SHORELINE EXEMPTION PERMITTING

SX-17-00016 Shorelines Exemption

SX-17-00016 Botkin

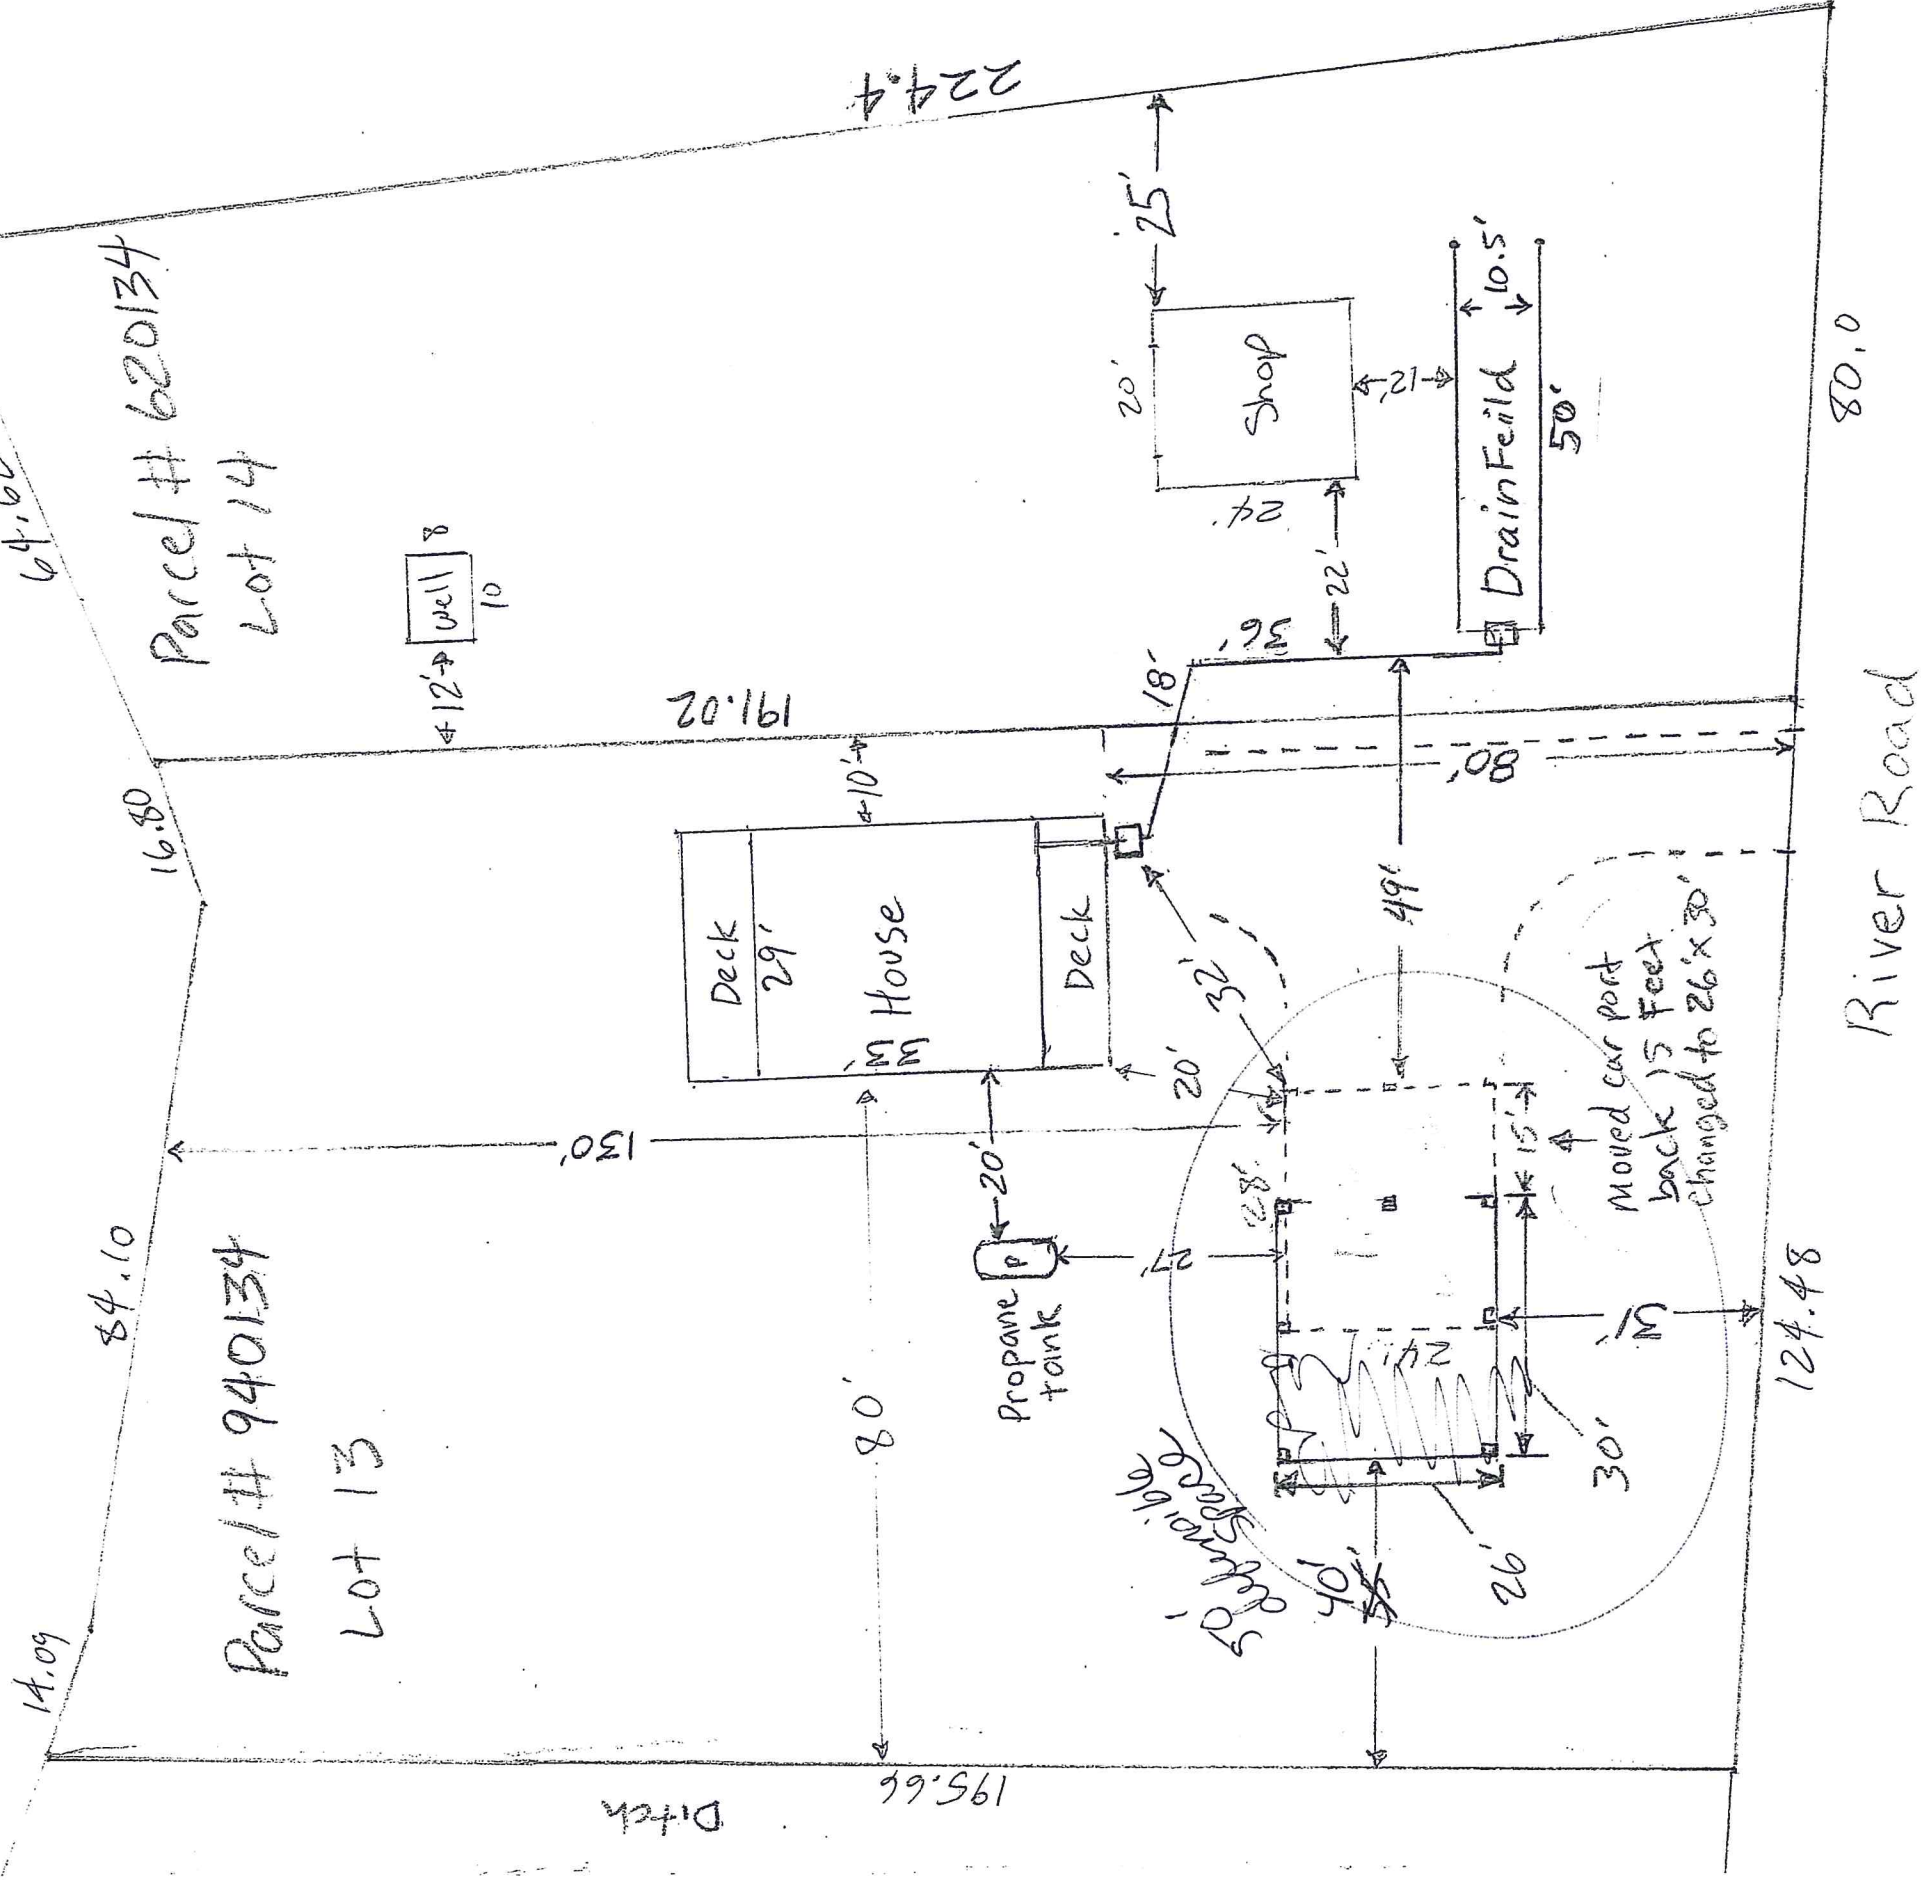
Greetings from Kittitas County Planning. I am currently reviewing your shoreline exemption application, and I may require additional information to continue processing. Looking at the site plan, it shows the distance from the proposed structure to the property line, not the Ordinary High Water Mark (OHWM). I would like to visit the site and make a determination as to the precise location of the OHWM, and from there make sure location of the proposed structure is accurately known relative to the OHWM. I booked solid through next week, but the week of October 2nd looks open. Please let me know if this works.
